Ribble Valley Borough Council
By email

Your ref 3/2026/0295
Our ref DC/26/1377
Date 14-JUL-26

Location: Brian Holden Memorial Playing Field Mardale Road Longridge PR3 3EU
Proposal: Proposed synthetic turf pitch including fencing, spectator areas, storage areas and floodlighting

SITE PLAN

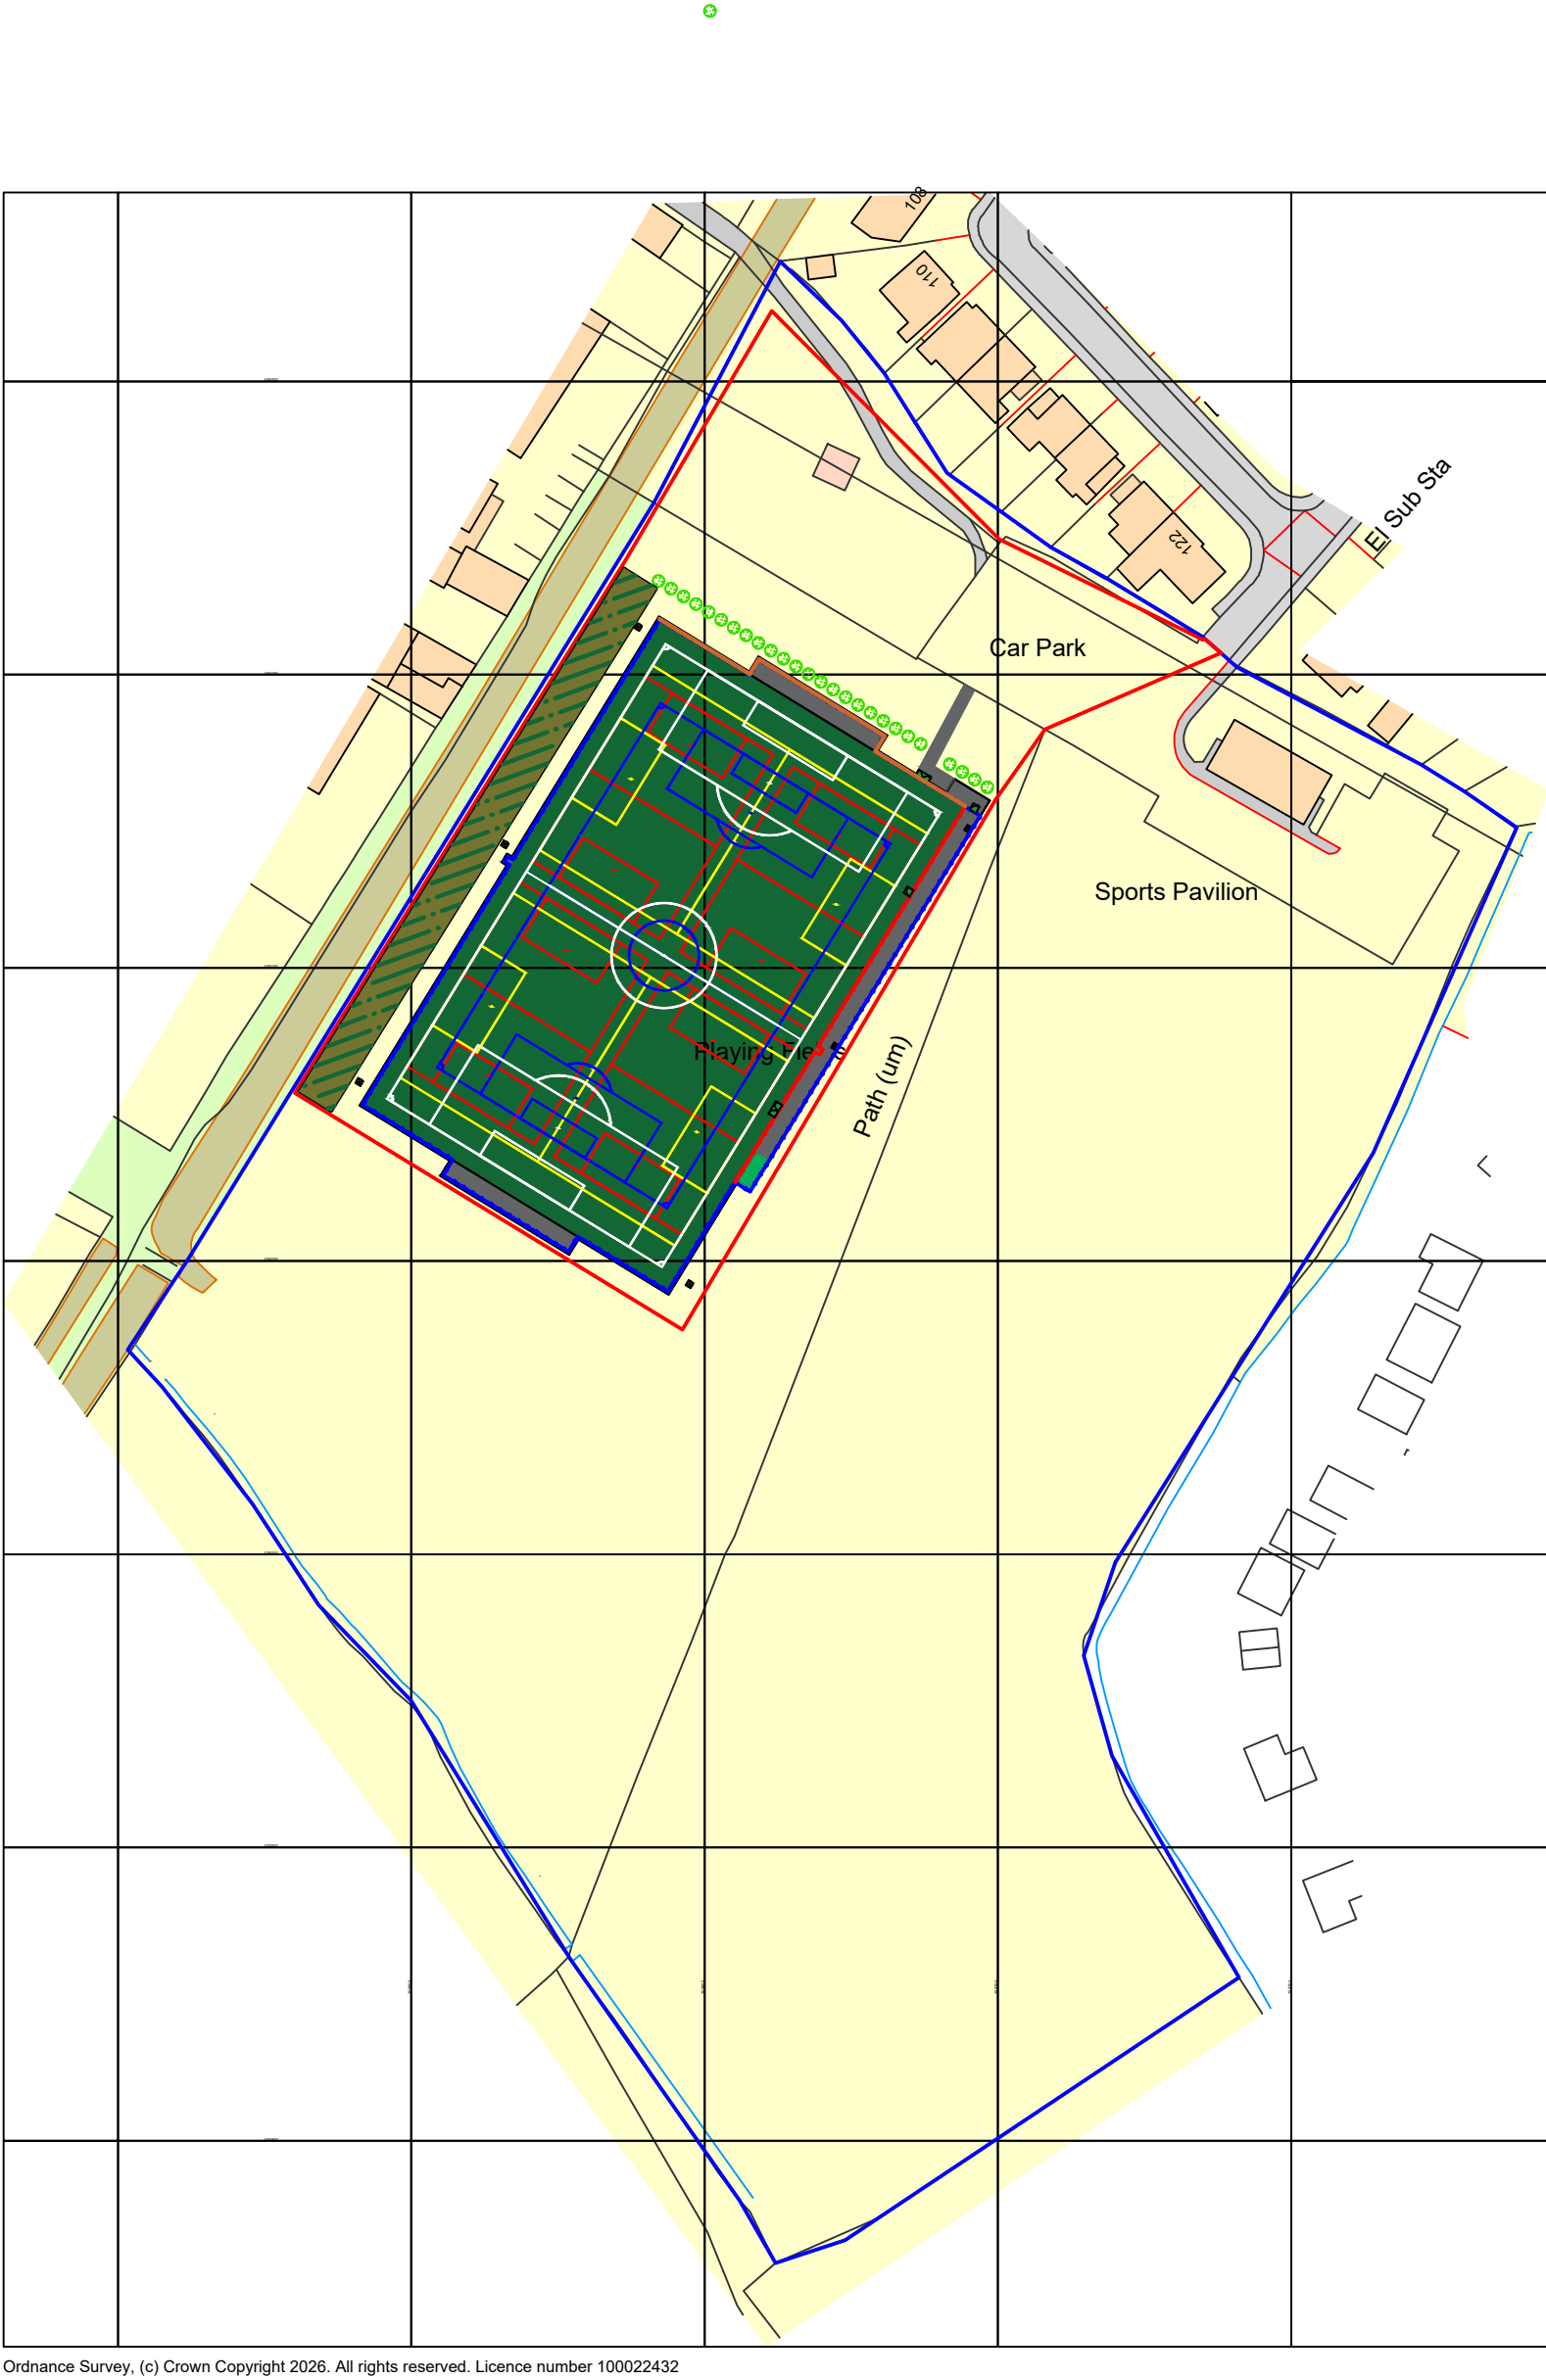
A public sewer crosses the site, and we will not permit building over it. We require an access strip for maintenance or replacement and this access must not be compromised in any way. The minimum distances that might be acceptable to United Utilities are detailed within Part H of the Building Regulations however, we recommend the applicant determines the precise location, size, depth and condition of the pipeline as this is likely to influence the required stand-off distance from any structure.

Based on the information currently available, it is unclear whether sufficient distance is provided between proposed development features and our wastewater asset(s). We recommend the applicant contacts our Developer Services team to ensure existing wastewater assets, along with our required access widths, can be accommodated in the proposed layout. If the applicant fails to investigate and resolve any concerns prior to a positive determination, there is a risk that as the scheme progresses, the applicant, or any subsequent developer, may discover that their plans are not implementable in their existing form or that diversion of assets is required. If the Local Authority requires any additional comment on the acceptability of the proposed layout from United Utilities, we will require a detailed site layout plan, which overlays the PROVEN location of the wastewater asset(s) in relation to any proposed development (including walls, fencing, parking etc.). In this scenario, we will require evidence to show that the location of the pipeline(s) has been confirmed by site specific survey, a copy of asset maps will not suffice.

It is the applicant's responsibility to investigate the existence of any pipelines that might cross or impact their proposed site and also to demonstrate the exact relationship between United Utilities' assets and the proposed development. The applicant should not rely solely on the detail contained within asset maps when considering a proposed layout.
